From: [Aaron Mostofi](#)
To: [Dusty Pilkington](#)
Subject: RE: VA-16-00001 Mostofi
Date: Wednesday, October 12, 2016 12:55:01 PM

RE: VA-16-00001 Mostofi

1. The CDS Building Division has no objection for the applicant to encroach into the setback. Distance to be determined by Planning Division.
2. Due to steep slopes on the property, full geo-tech and soils report is required as well

VA-16-00001

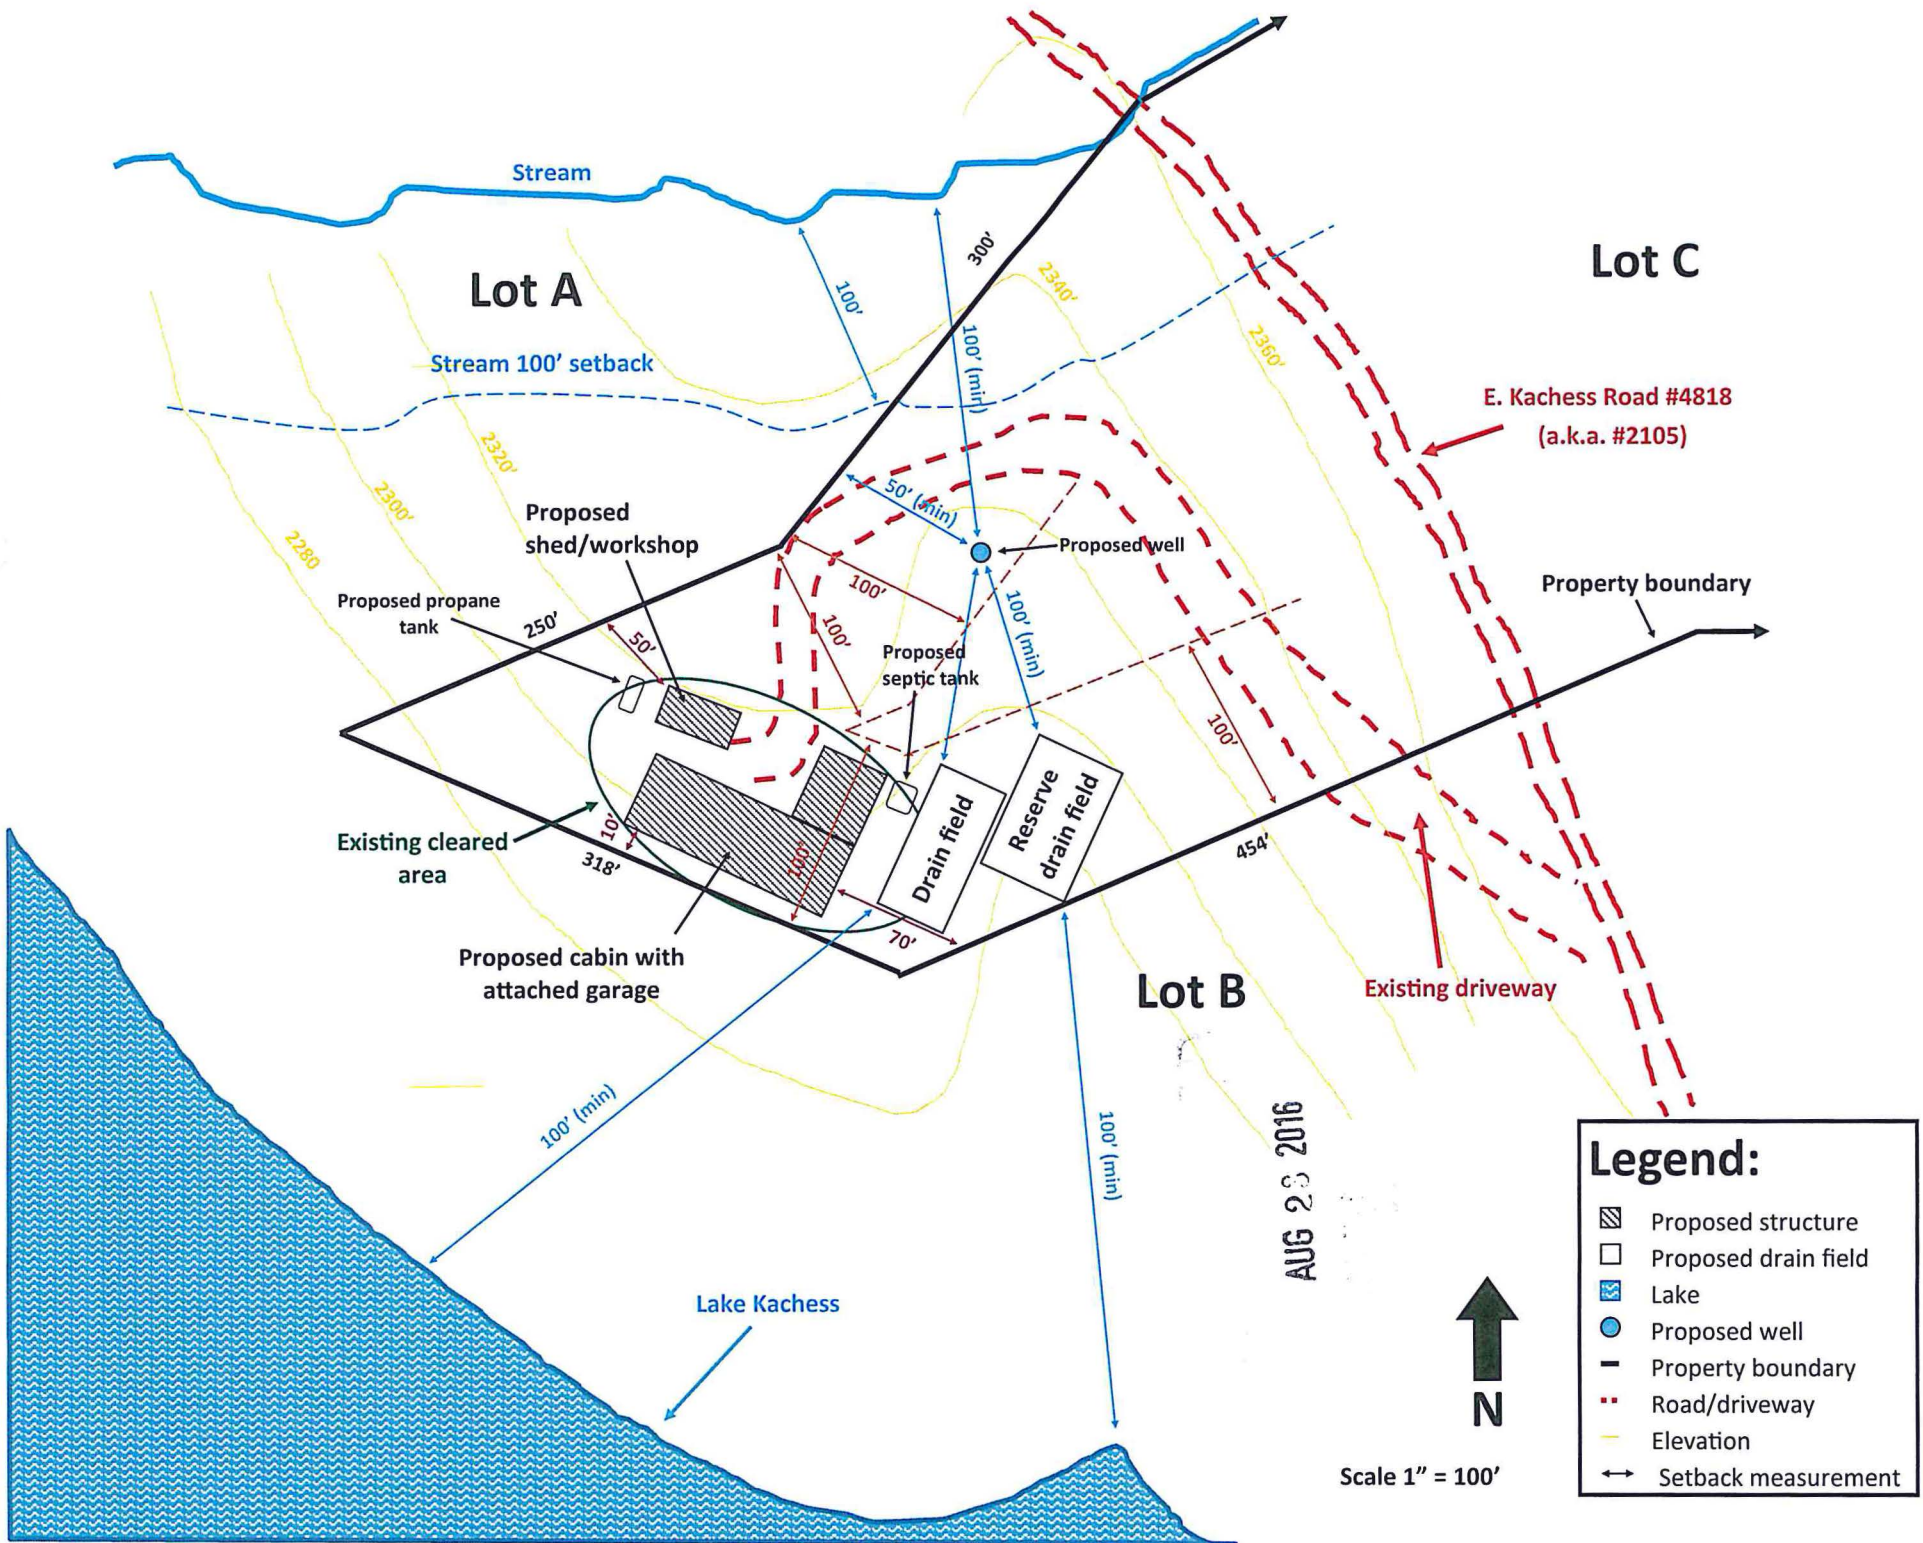
After looking at your site layout and the topo maps, nearest I can tell, you may very well be building outside the steep slope area of your property. Our GIS mapping may not be entirely accurate so we like to error on the side of caution.

If you supply a good cross section of the property and proposed building foundation (similar to the attached picture) we could make the determination that you do or do not meet these requirements. If however our inspectors on site for the first footing inspection determine otherwise, if perhaps the building were moved or shifted too close to a setback, geo-tech could still be required.

as engineered building plans.

I don't think I've seen a better method of mapping out the slope and providing us the exact dimensions as this.

I have shared this with our office and this more than suffices for proof of meeting slope and setbacks to slopes.

No additional information is required regarding setbacks to slopes.
